NORTH LINCOLNSHIRE GREEN ENERGY PARK

Summary Table of responses to
Section 51 Advice

PINS reference: EN010116

September 2022

4.7 Plans showing statutory or non
statutory historic or scheduled
monument sites or features of the
historic environment

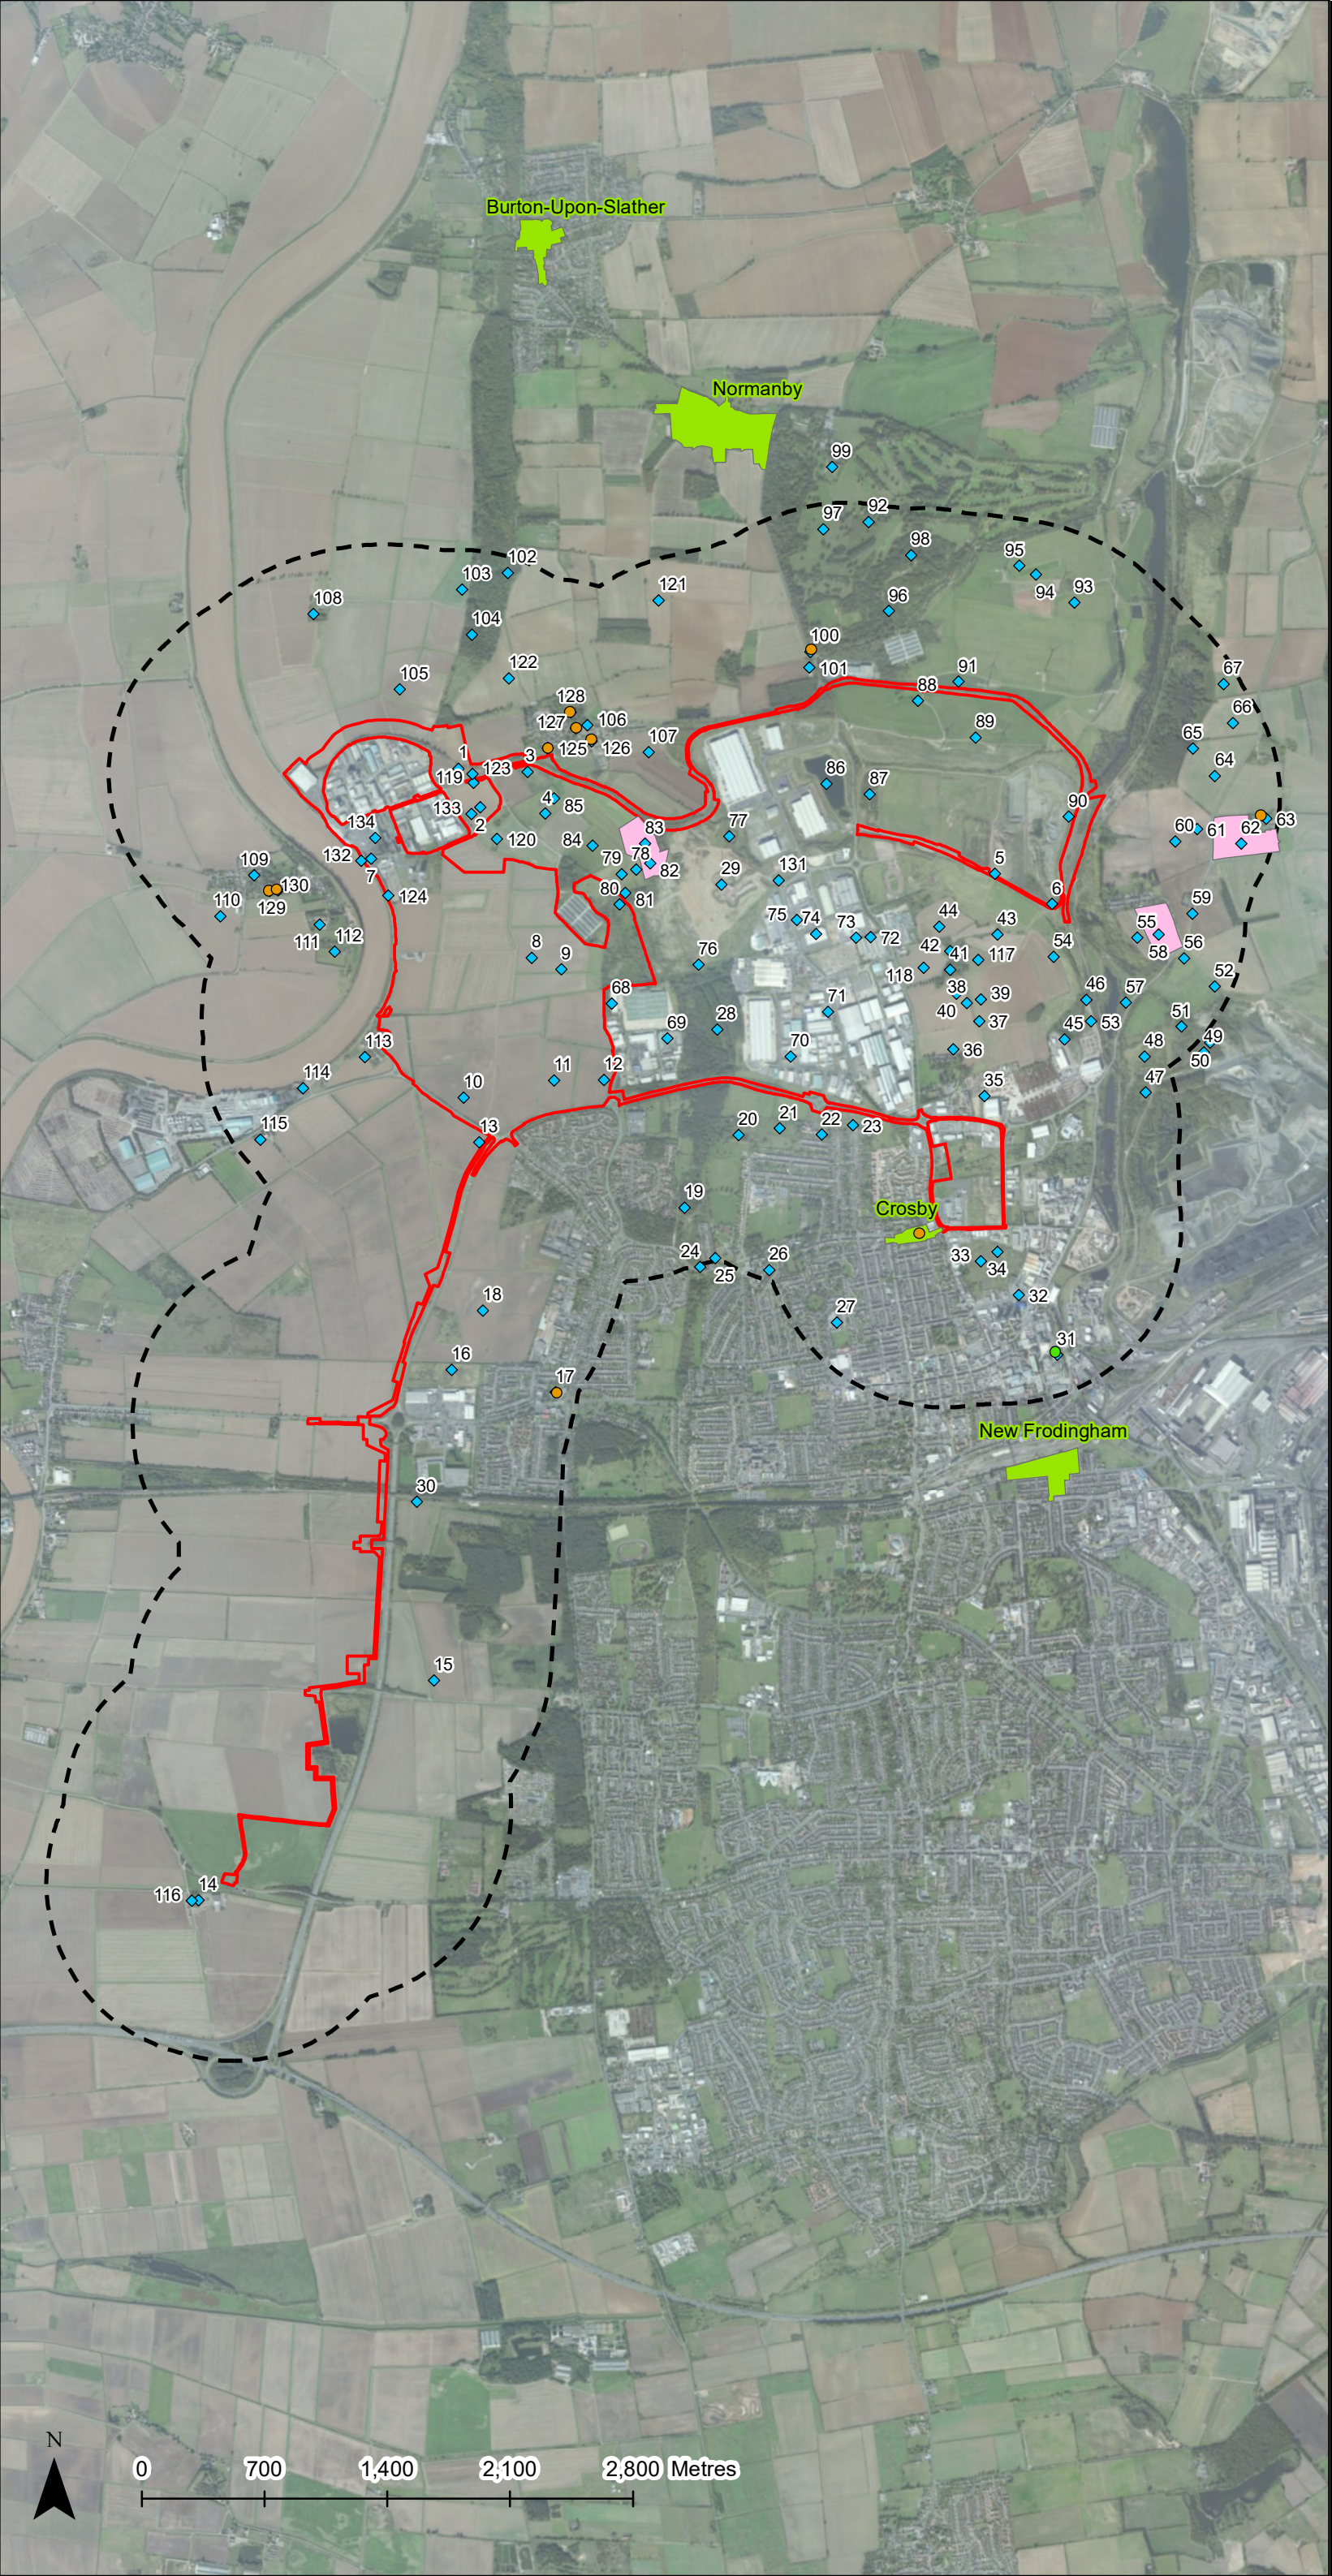
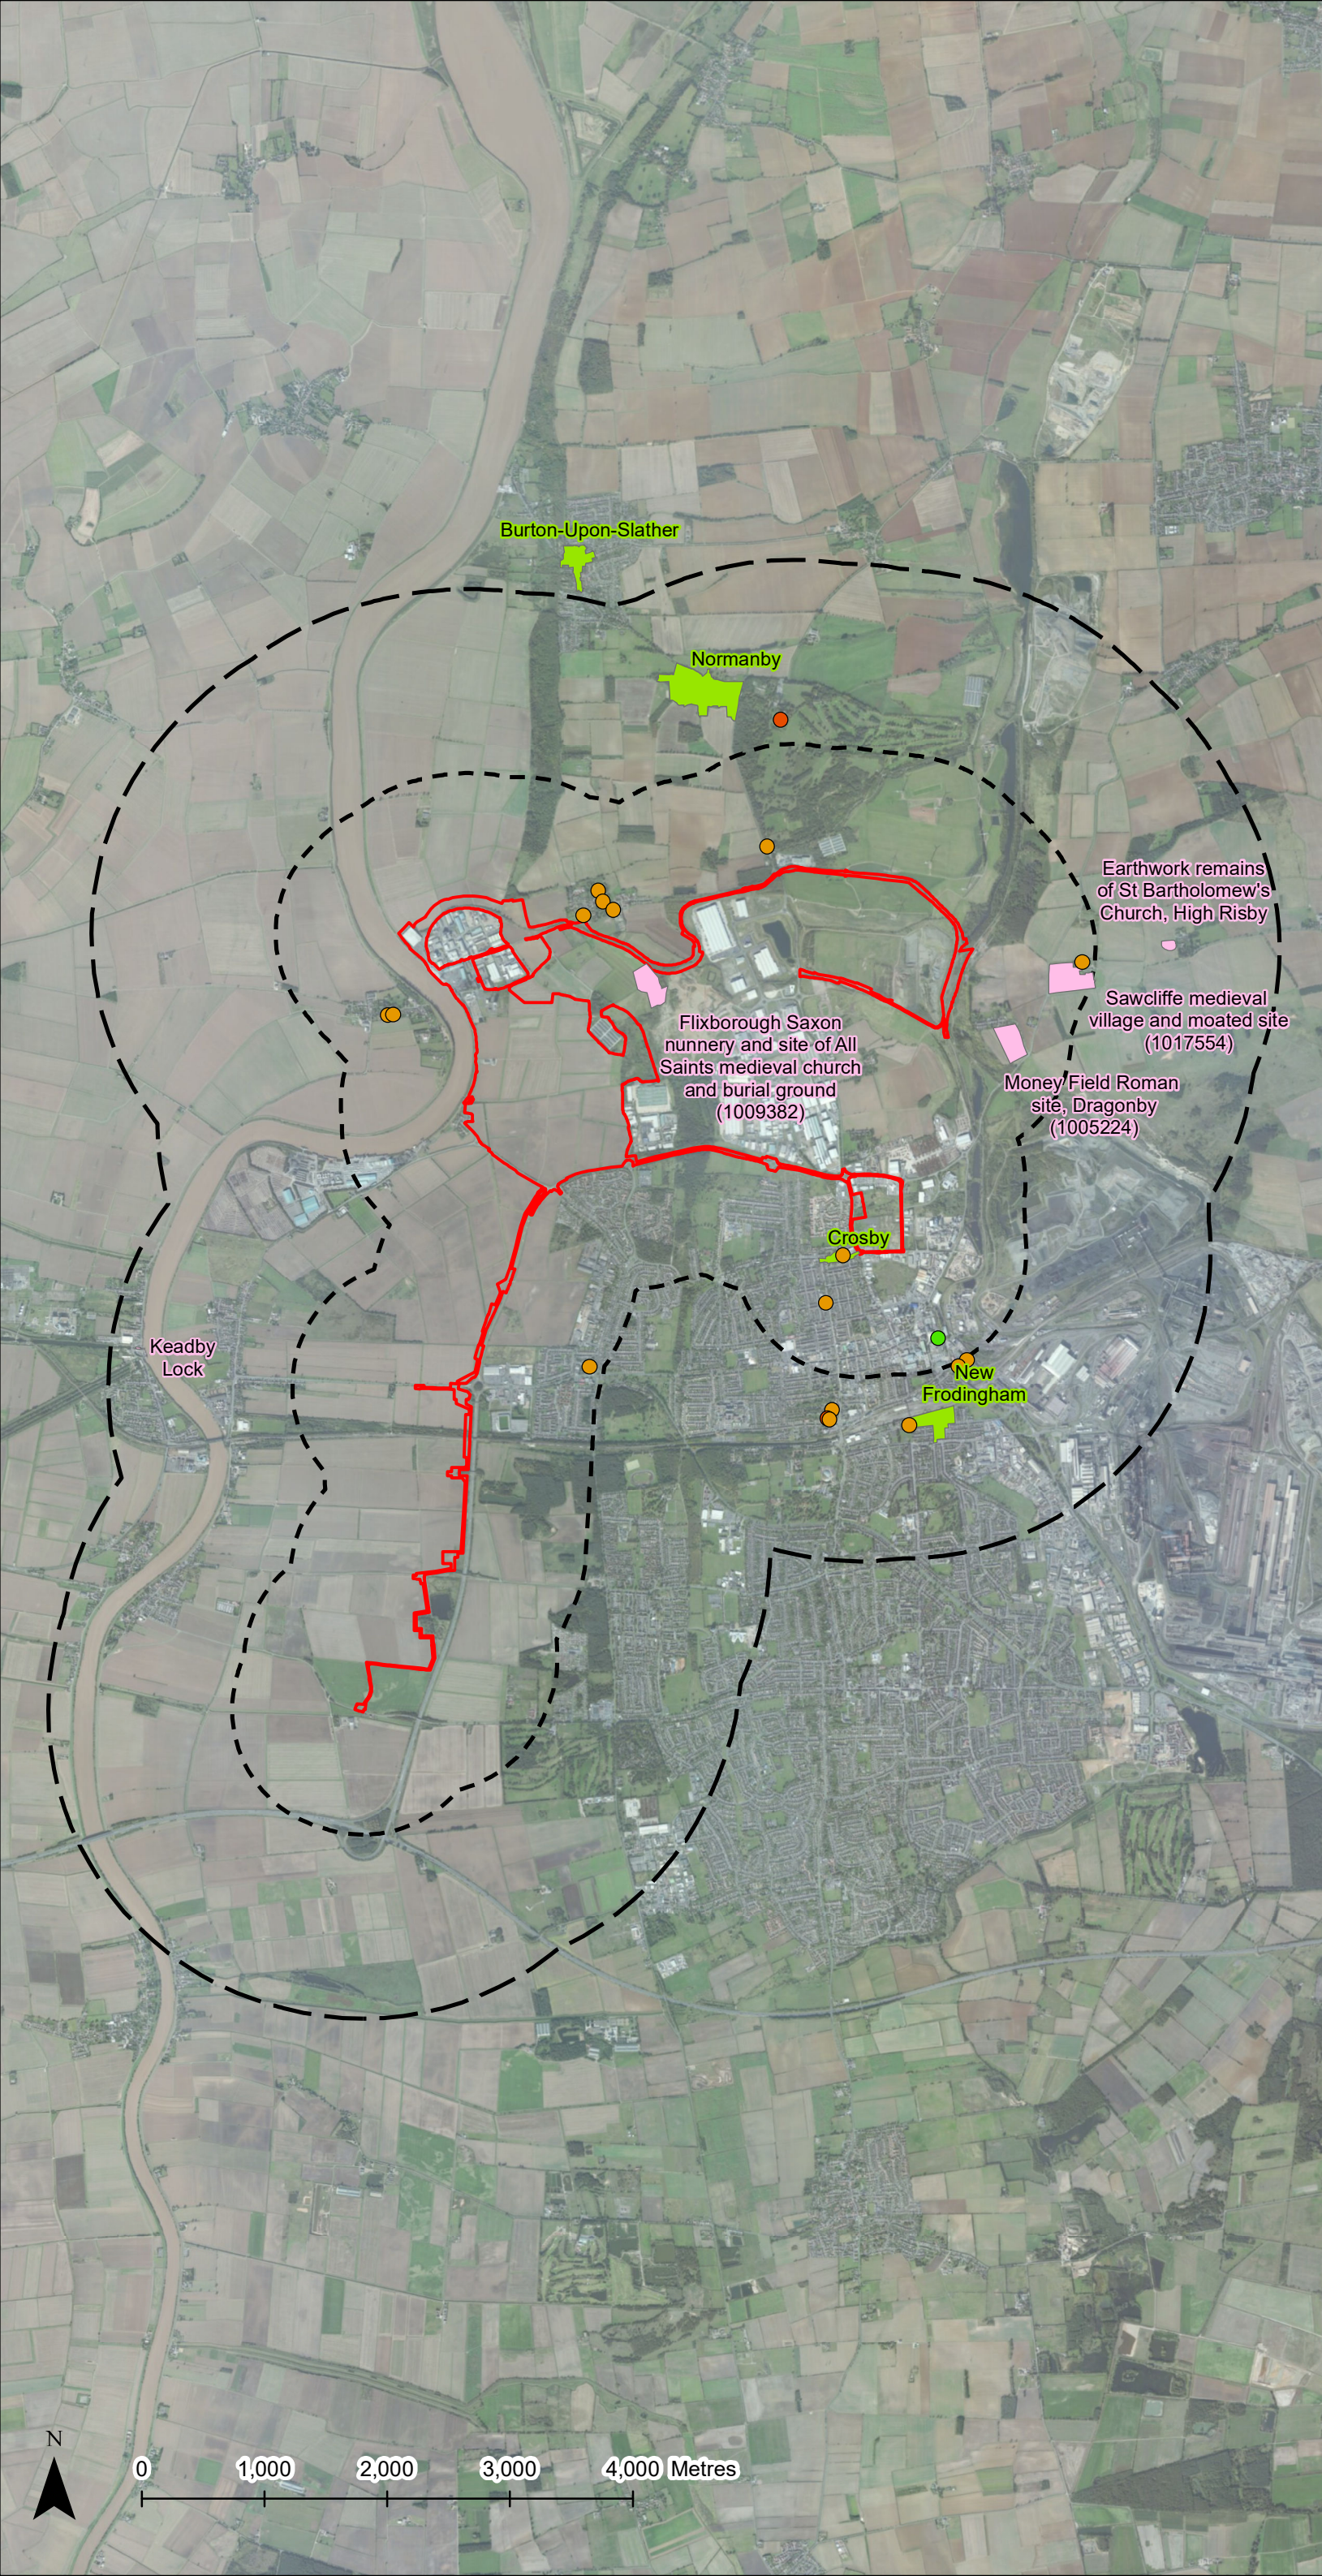
Relevant Document	Planning Inspectorate Comments	Applicants Response
<p>Plans showing statutory or non-statutory historic or scheduled monument sites or features of the historic environment (Document 4.7)</p>	<p>The plans do not show the Grade II listed building (Angel of War Memorial) which ES Chapter 12 (Document 6.2.12) states is located within the study area. The plans also incorrectly labels some designated heritage assets as non-designated heritage assets</p>	<p>This listed building has now been added and labelled as site 135 on the relevant maps. Another listed building, shown on maps but without a number – the Grade II number 45 and 47 Old Crosby - has also been numbered as site 136 in the relevant maps. Regarding the second part of this comment, <i>‘The plans also incorrectly label some designated heritage assets as non-designated heritage assets’</i>, this issue resulting from layering in our spatial database has now been resolved.</p> <p>It is acknowledged that this error occurs within other figures in the Appendices of Chapter 12. We will update these figures at the next appropriate point within the examination.</p>
